DRB Application No.: 05DRB-01631 (SBP)

Project Name: THE SPORTS COURT

**City Of Albuquerque
PLANNING DEPARTMENT
October 26, 2005
DRB Comments**

RE: The Sports Court/SPB

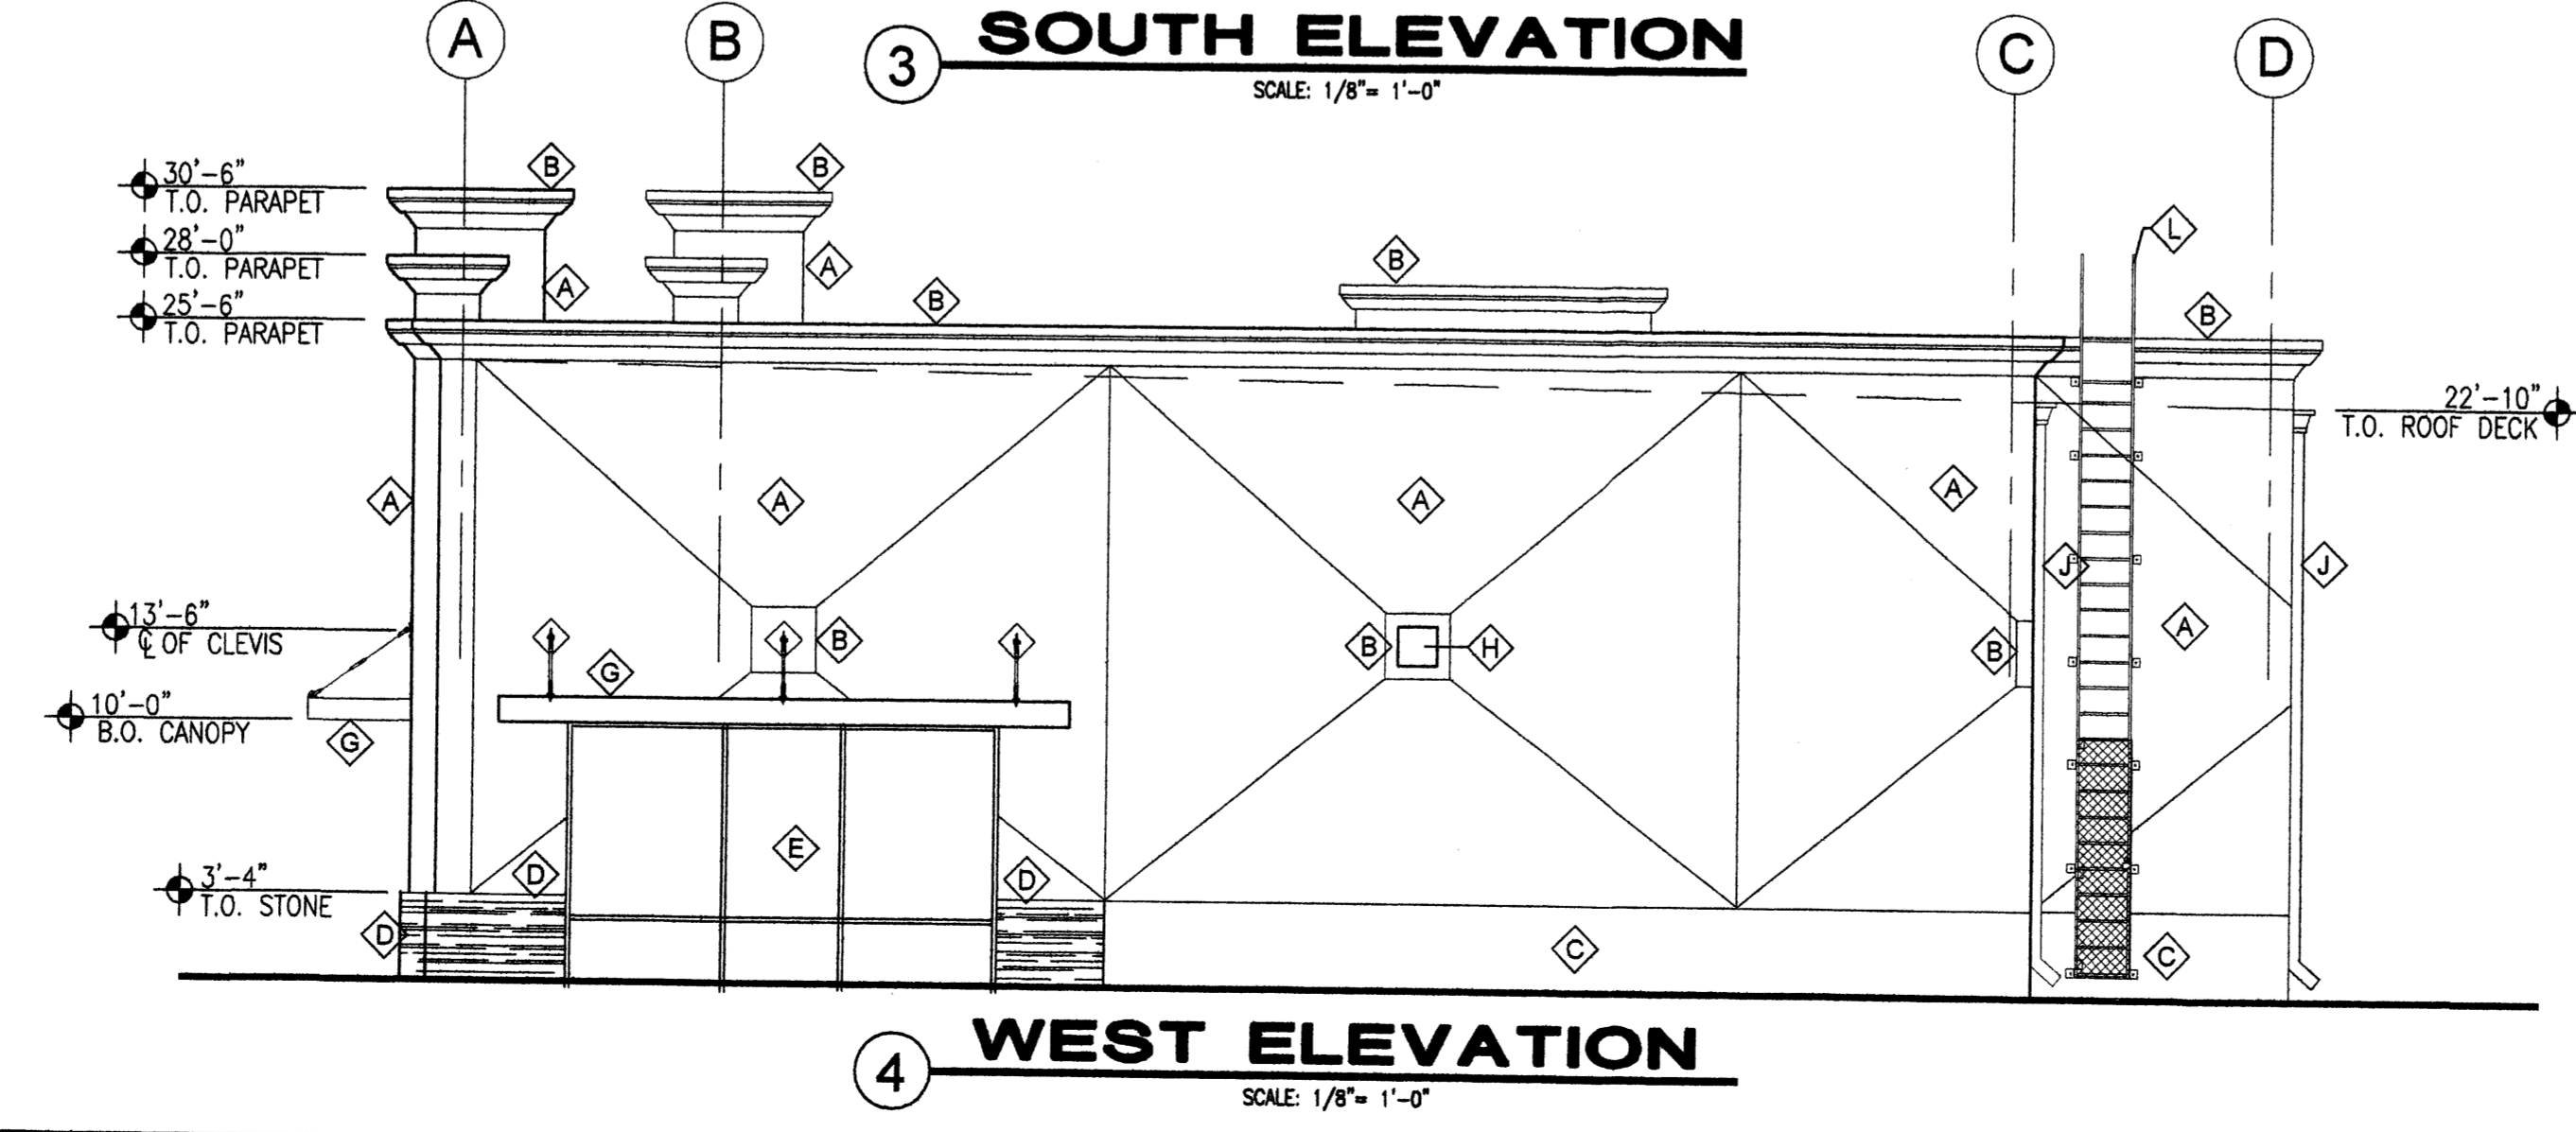
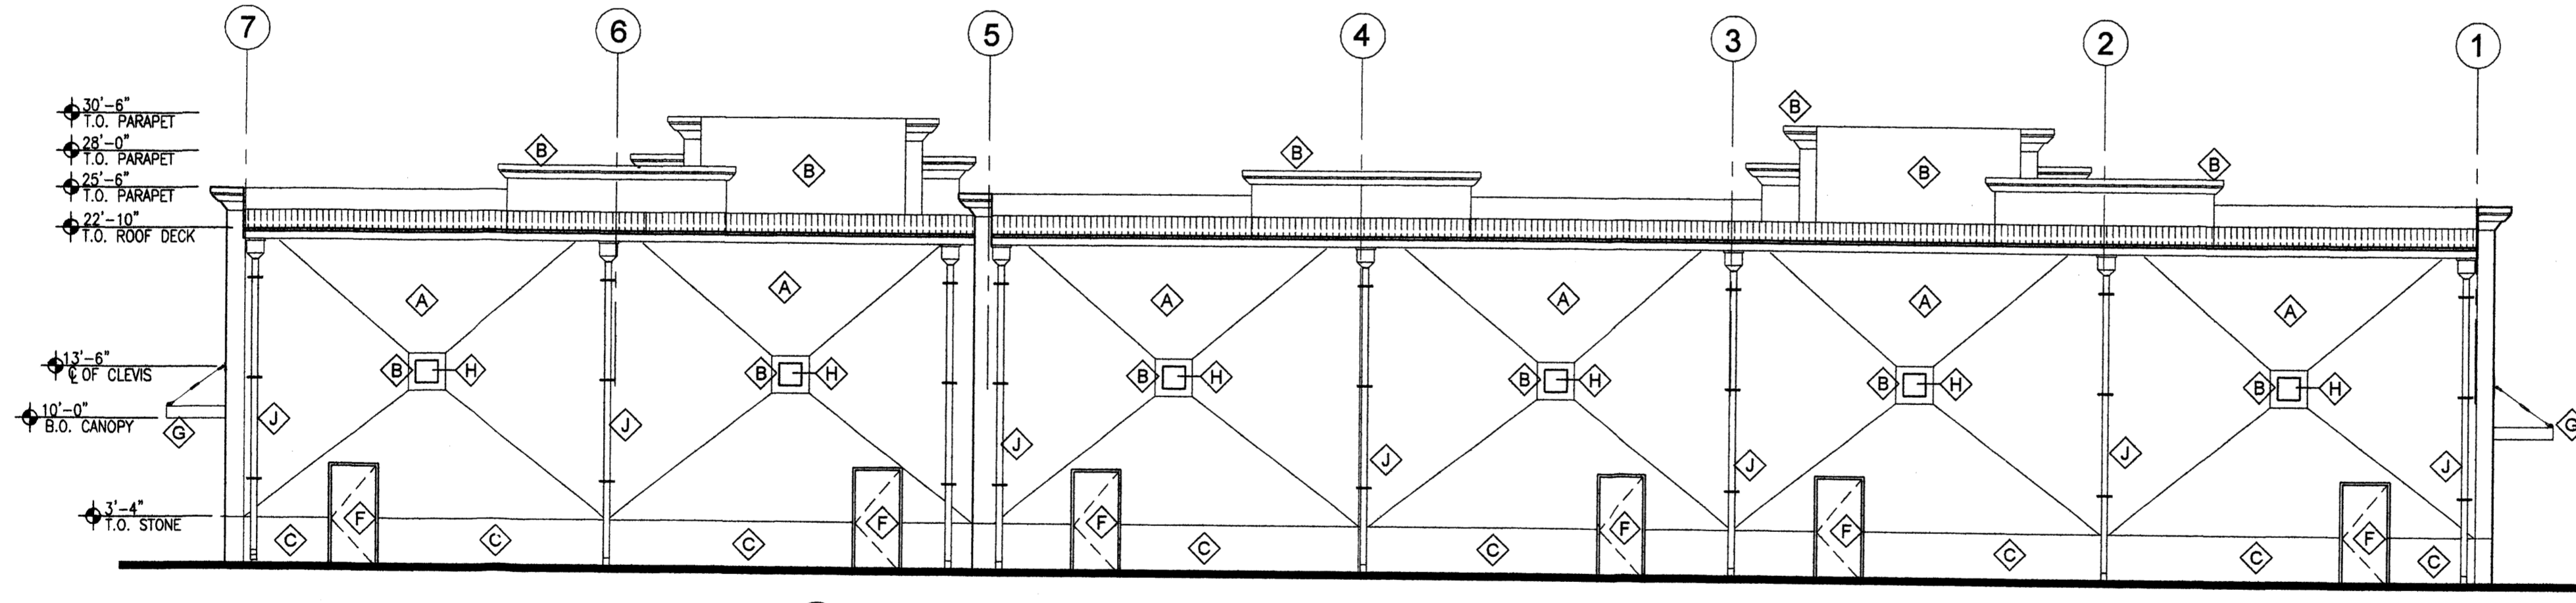
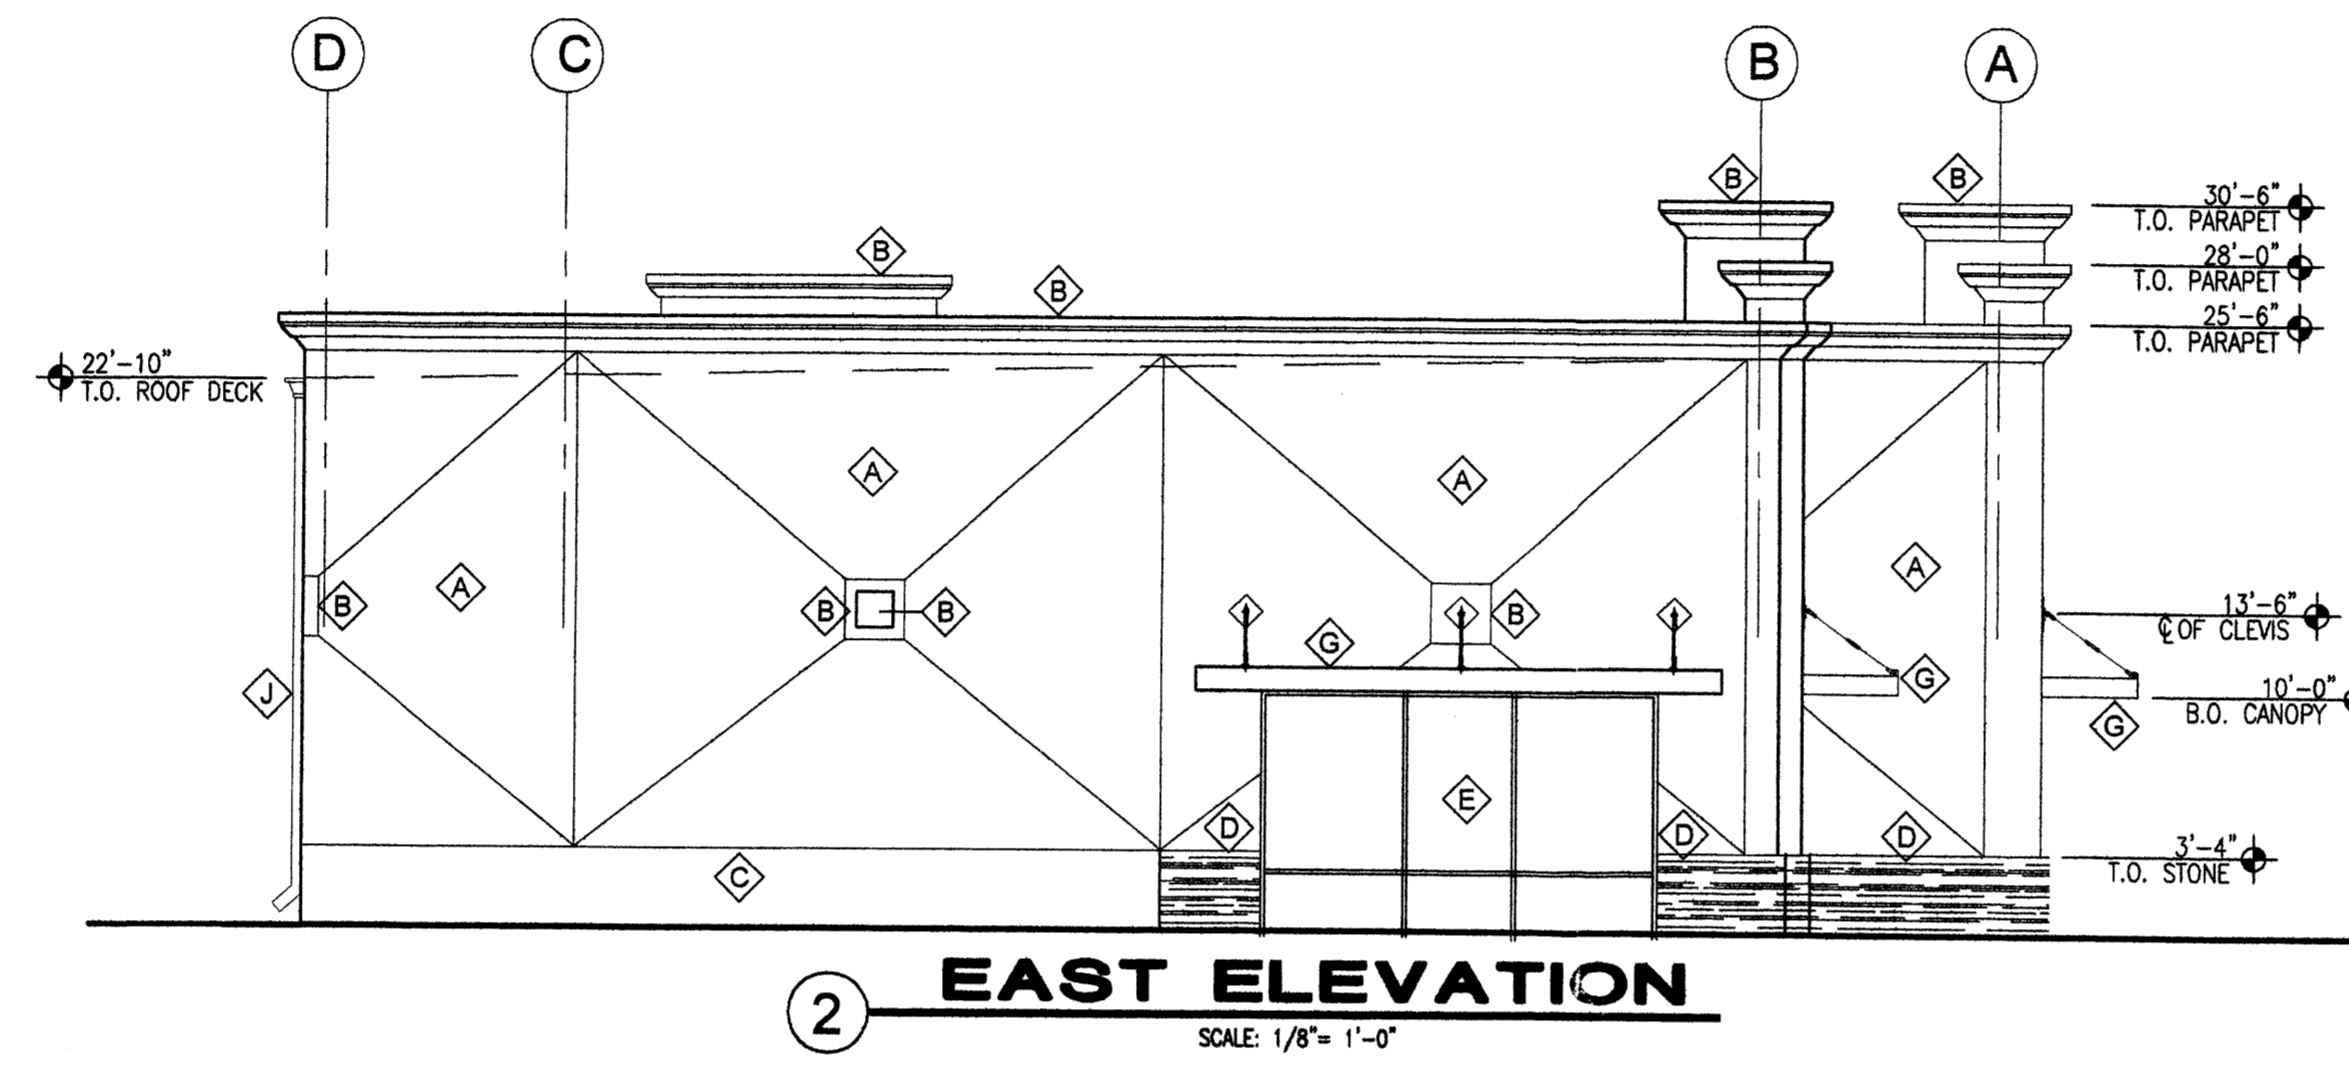
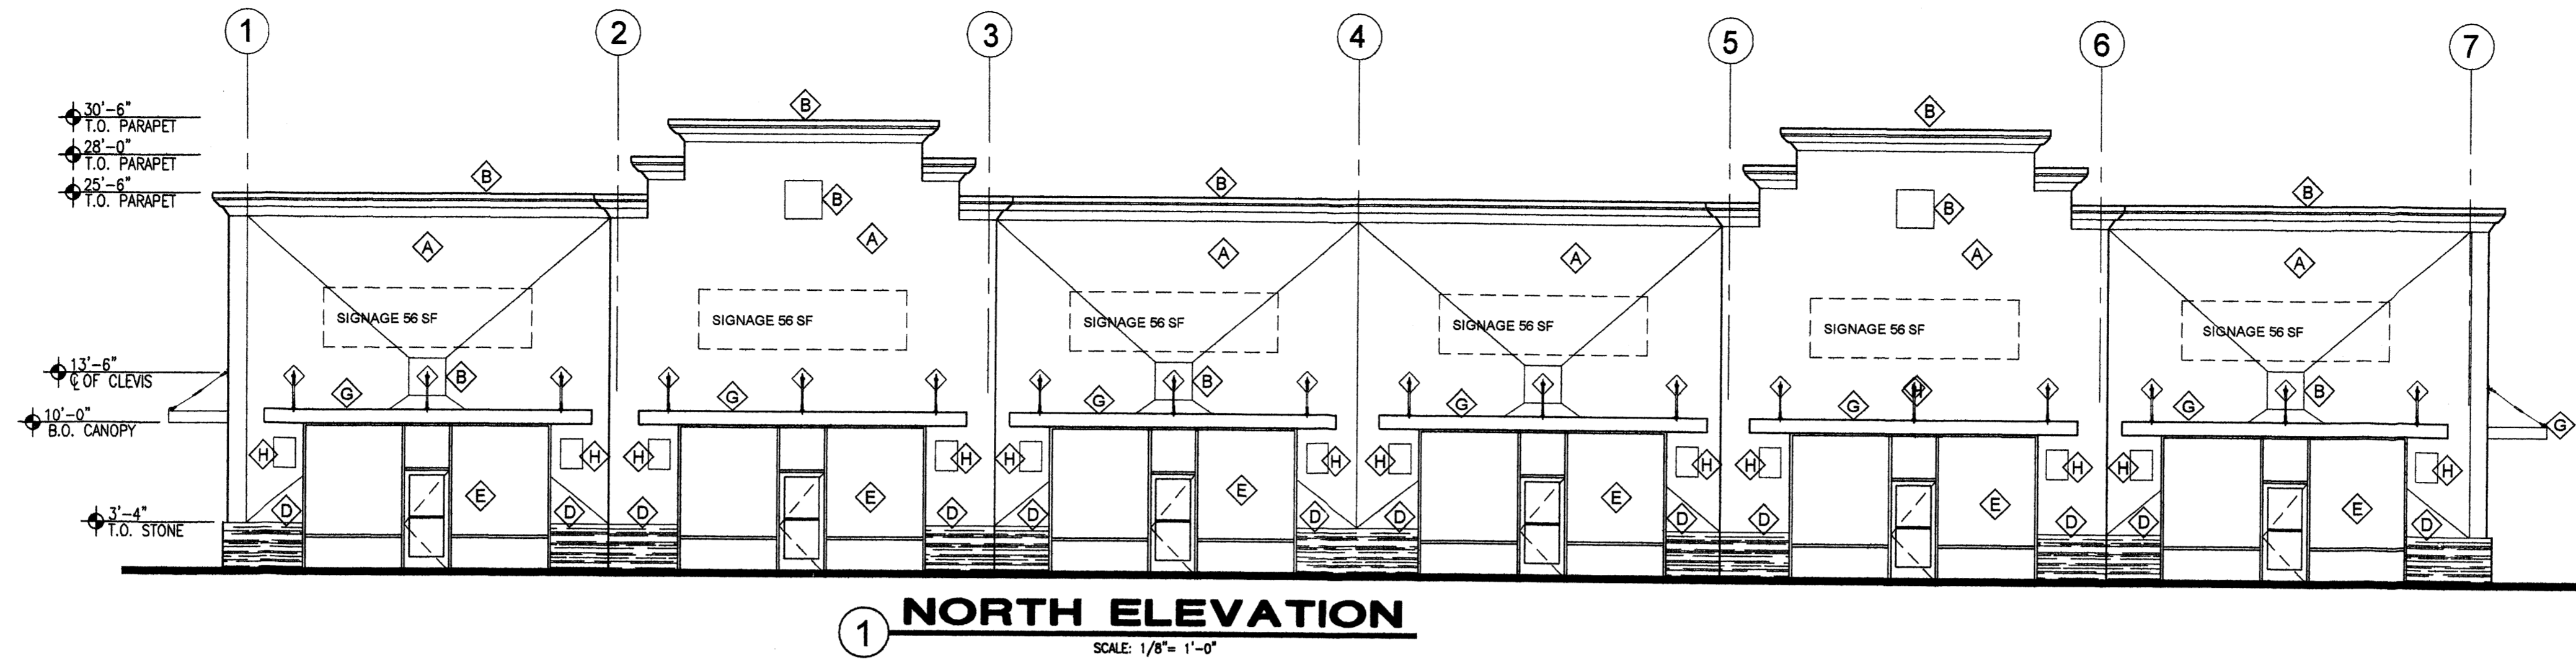
There are two elevation drawings, one for JA1/JA2 (A7) and one for Shops elevation (A7.1). Clarify what elevation buildings they correspond to.
